Emma Barnet - Comments - Proposed Modification to Visy's Paper recycling Plant 13/94 Mod 6

Proposed Modification to Visy's Paper recycling Plant 13/94 Mod 6

Council has reviewed the documentation submitted noting that Development Application 2012/127/1 (lodged with Council on 4 April 2012) is currently under assessment. The following comments are provided:

drawing title  
Swept Paths  
Cover Sheet  
(Option 1)

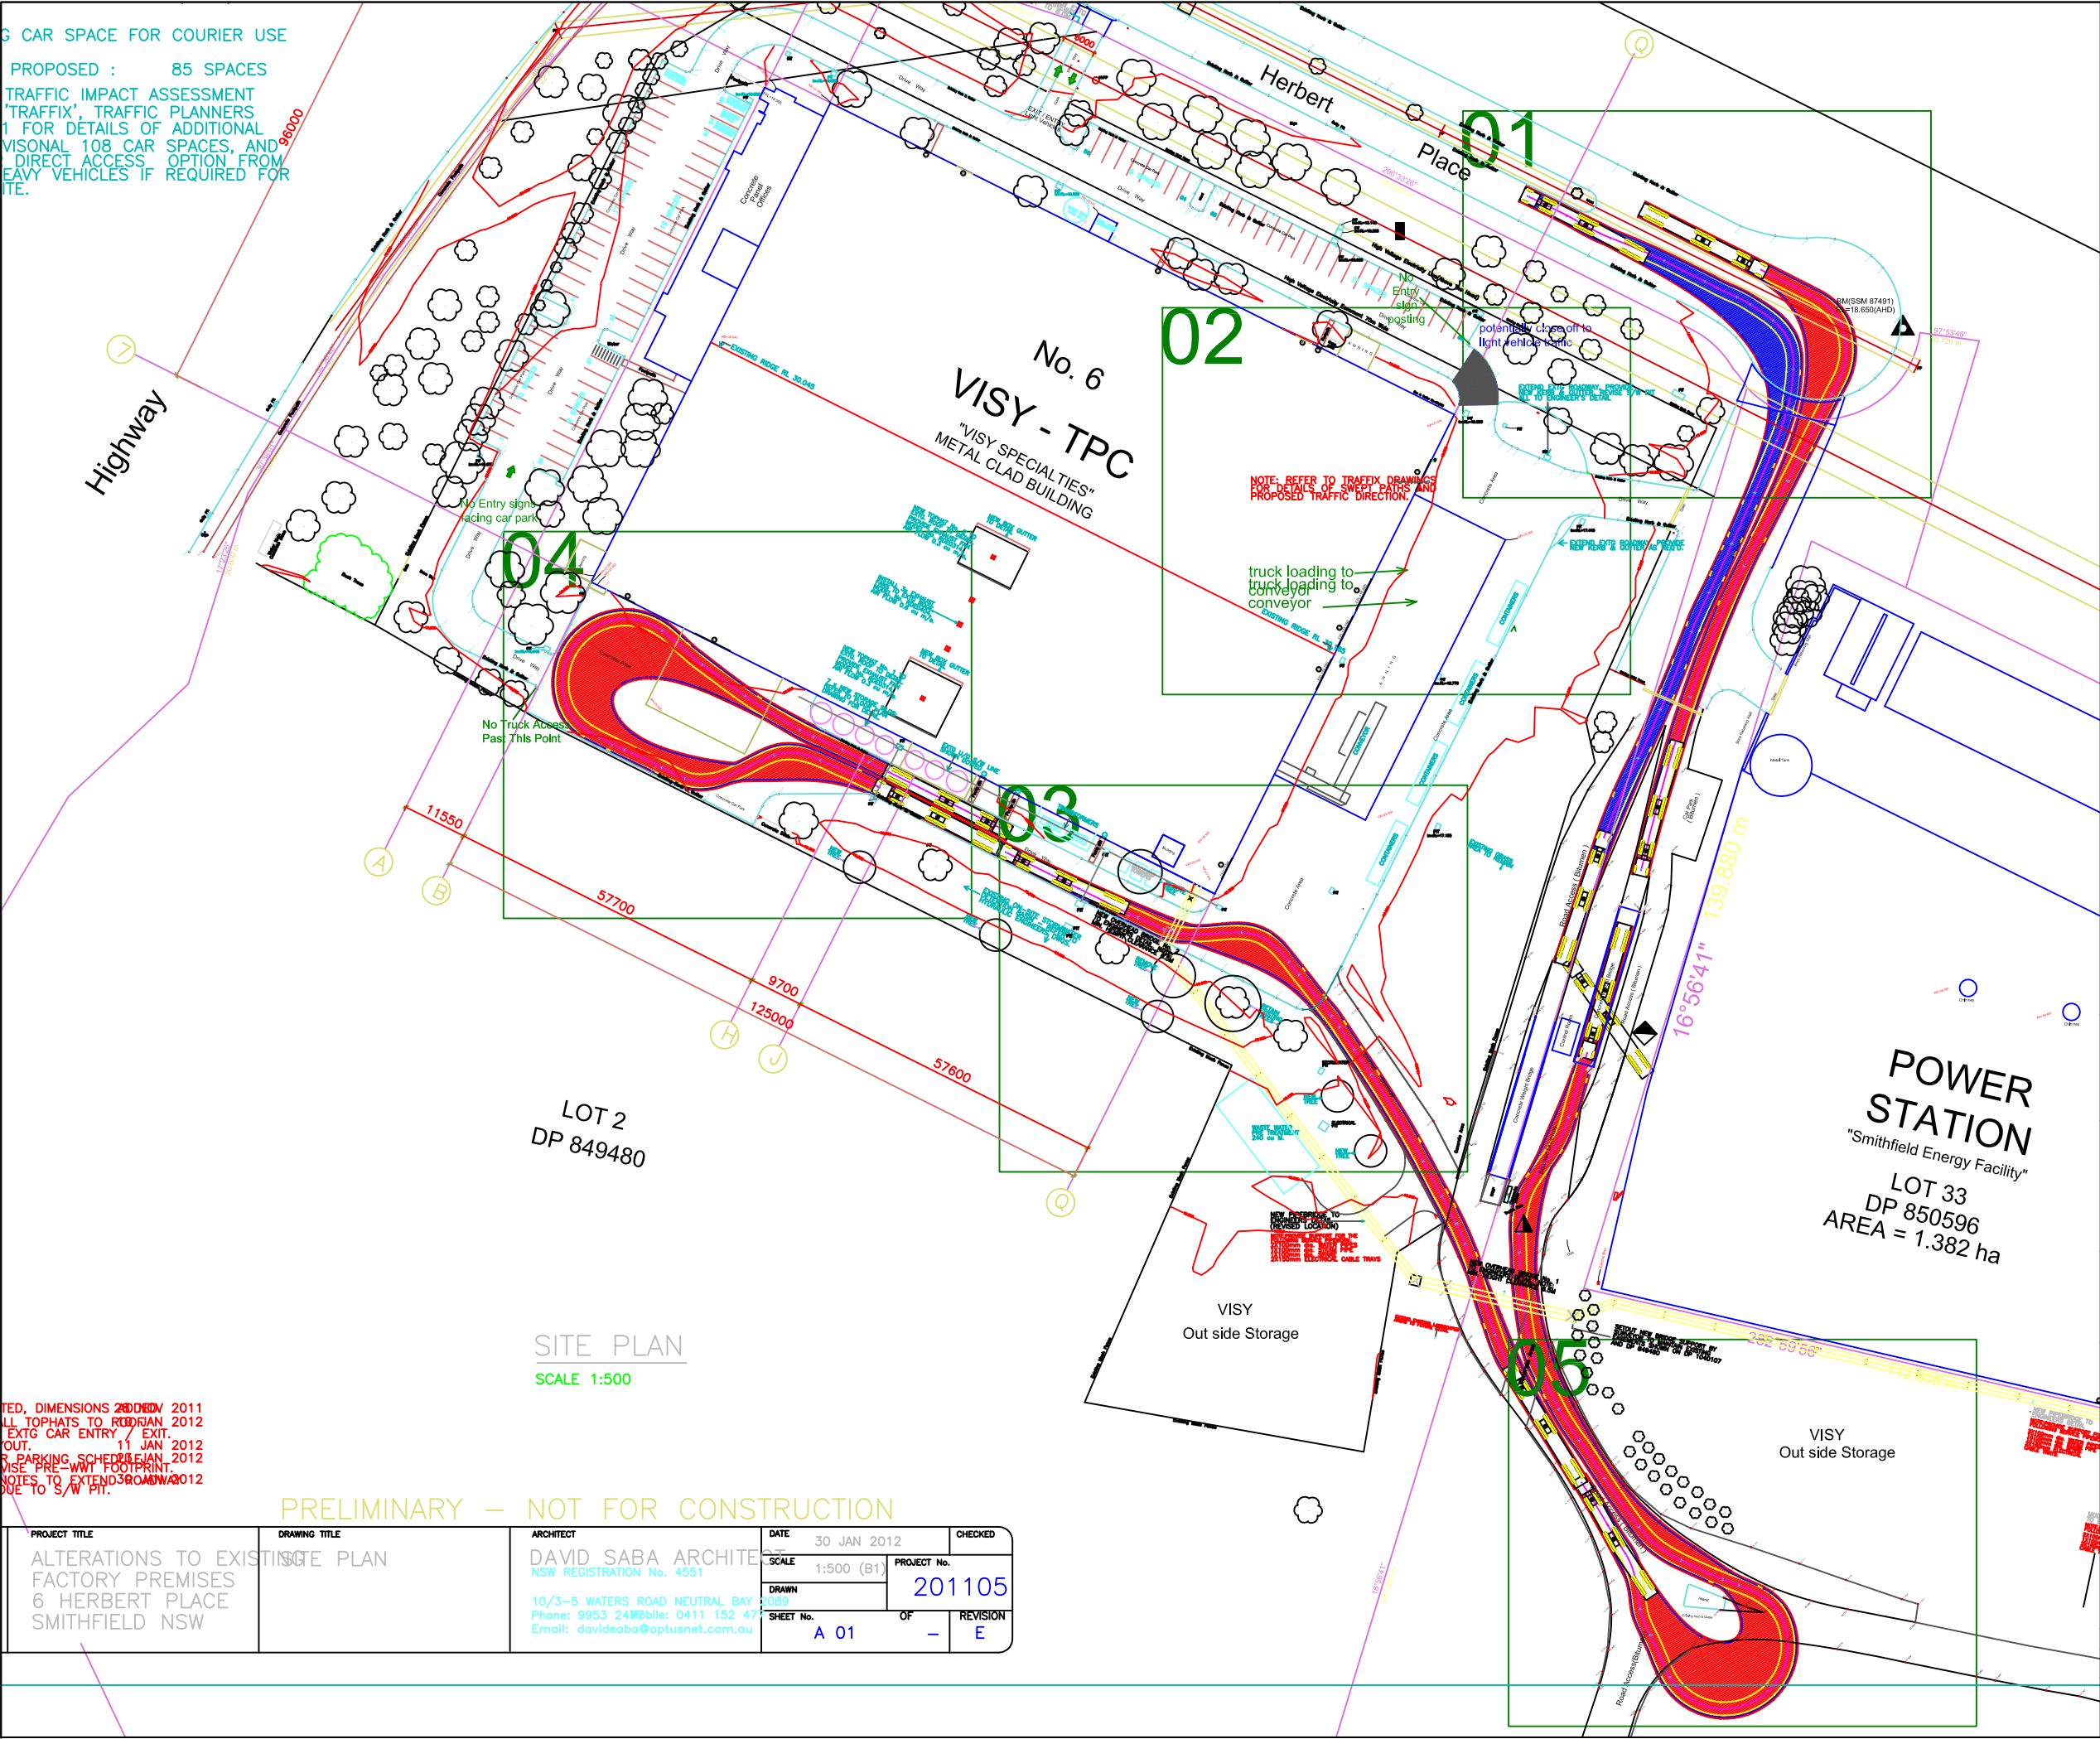
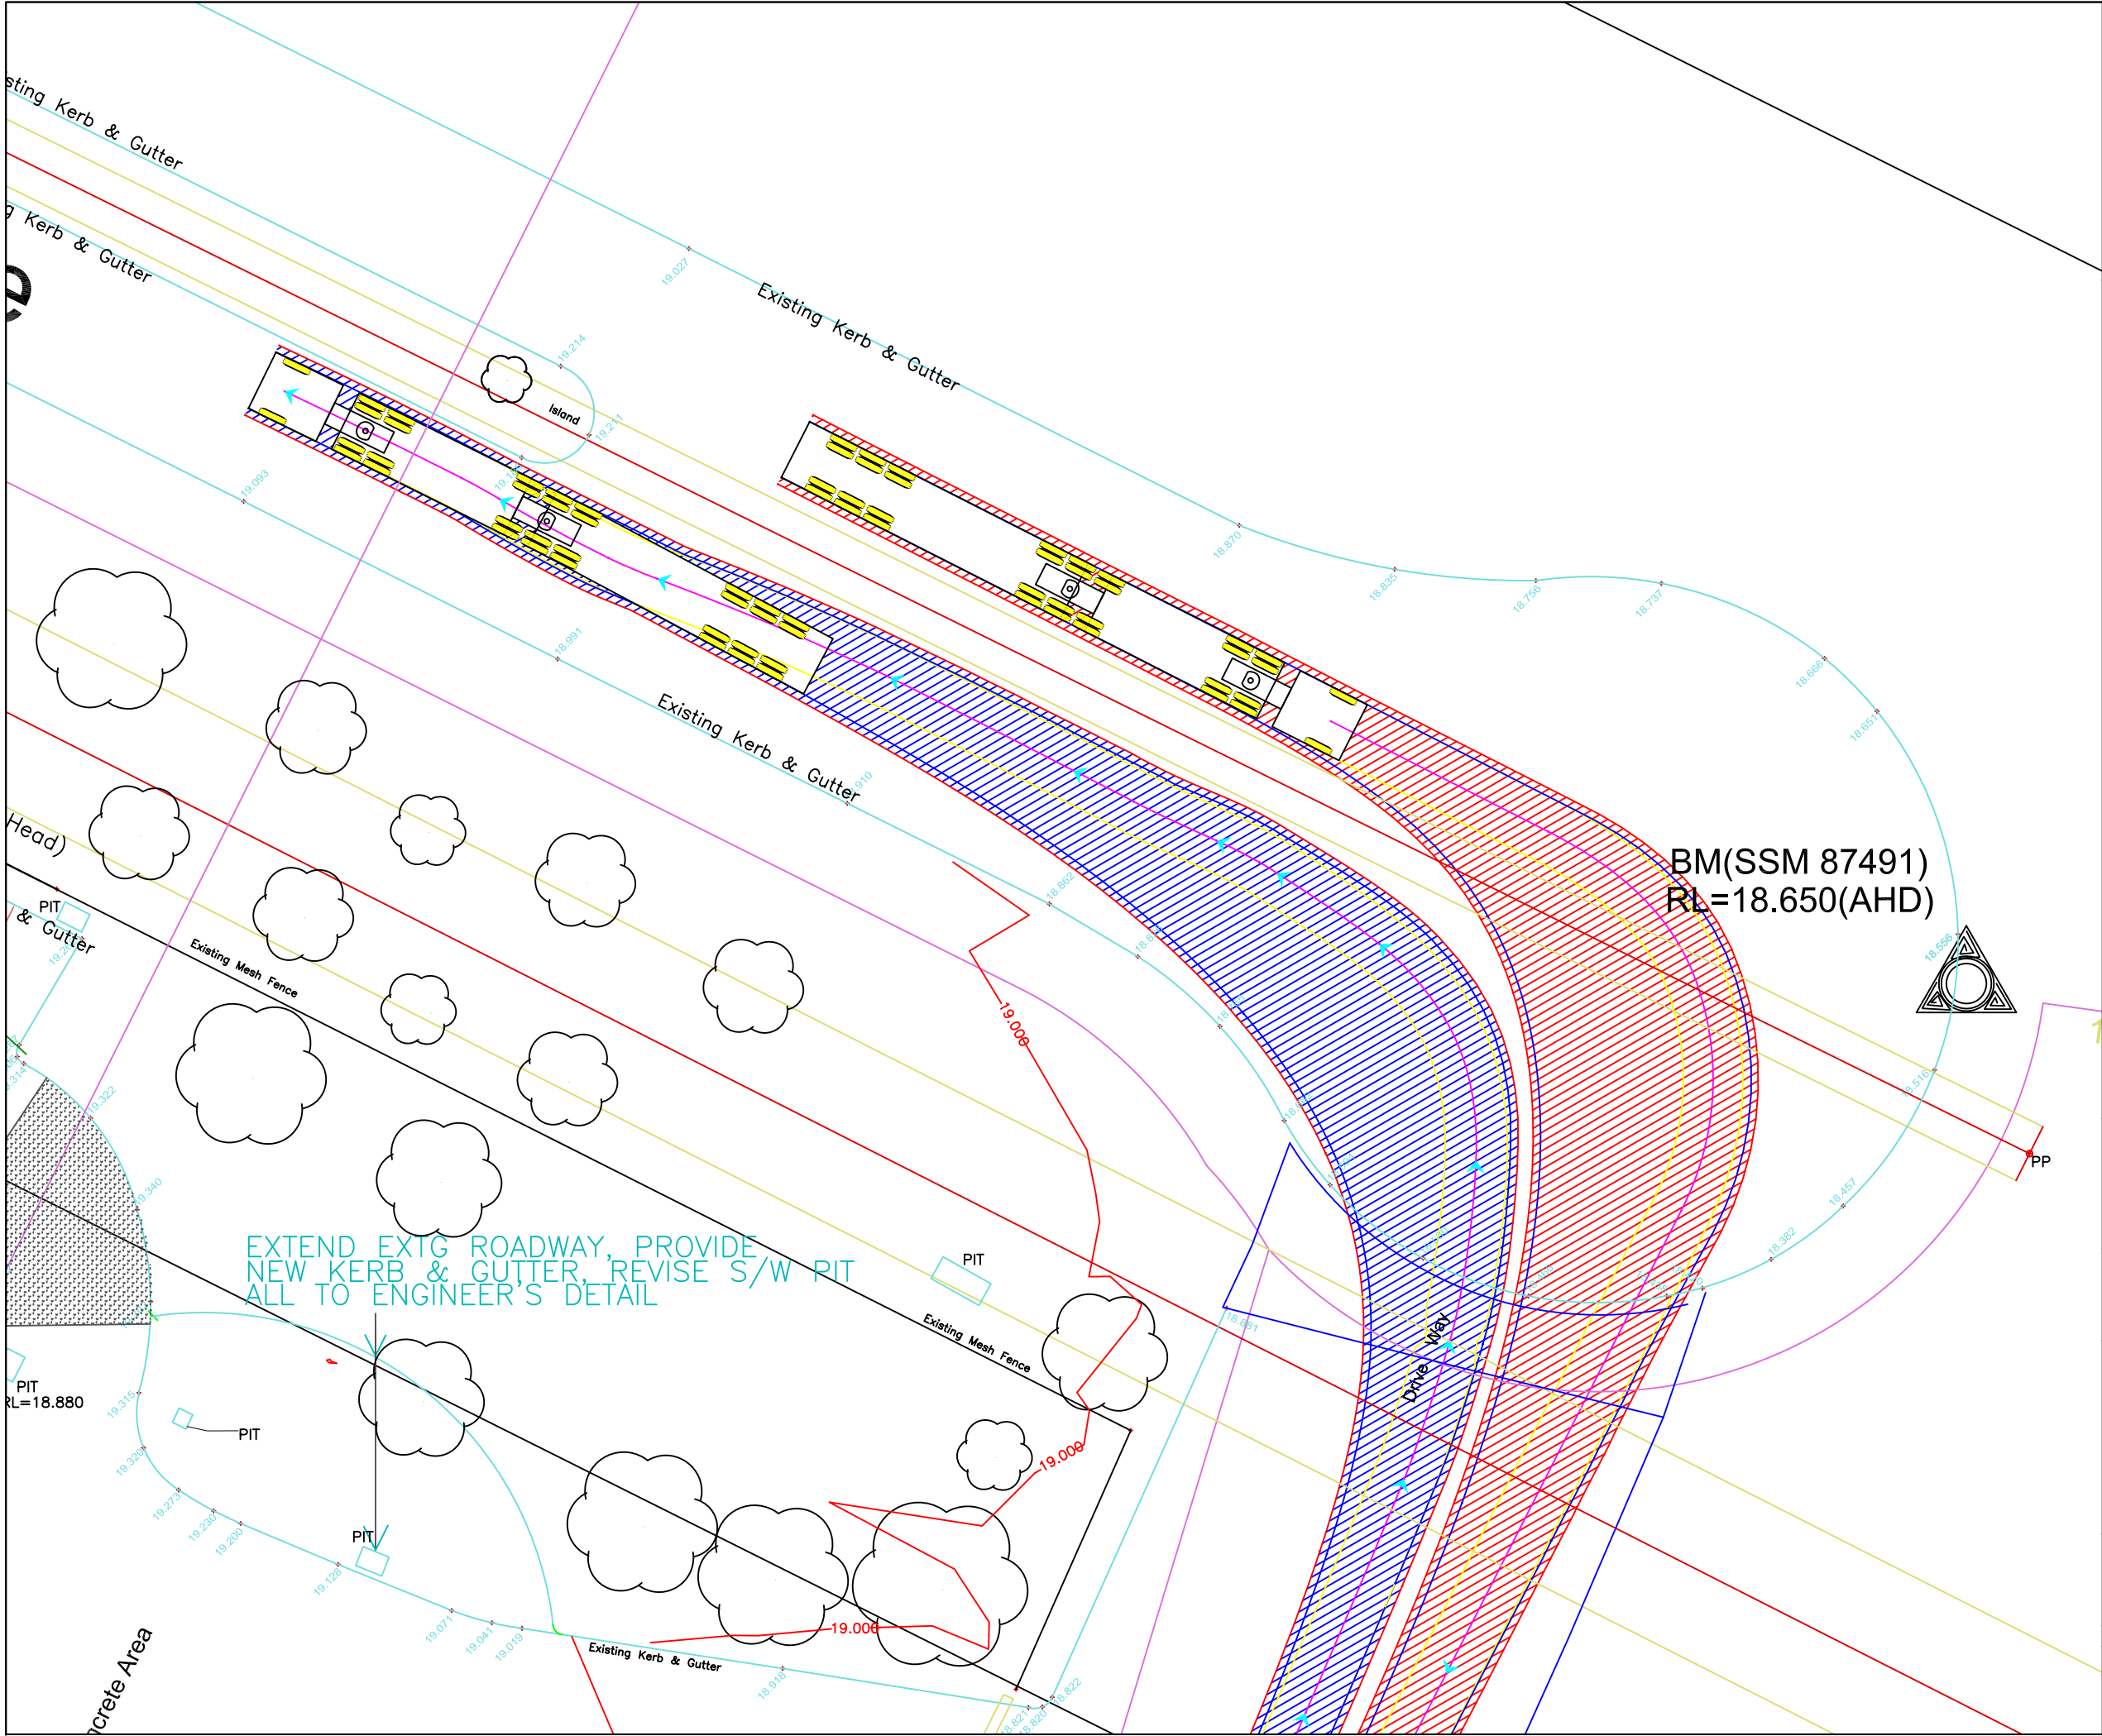
- The directional arrows for internal circulation shall be prominently displayed on the pavement on approaches to and within the carpark area.
 - The proposed shared driveway access (i.e. option 1) and swept path are acceptable subject to legal right of way being in place or construction of the proposed option (2) driveway and vehicles crossing.

- The design details of driveway access shall be showing on the map. The proposed option (2) vehicular crossing shall be widened to accommodate two-way traffic and in accordance with AS2890.2.2002. The swept path shall be prepared at this vehicular crossing while two vehicles passing each other.
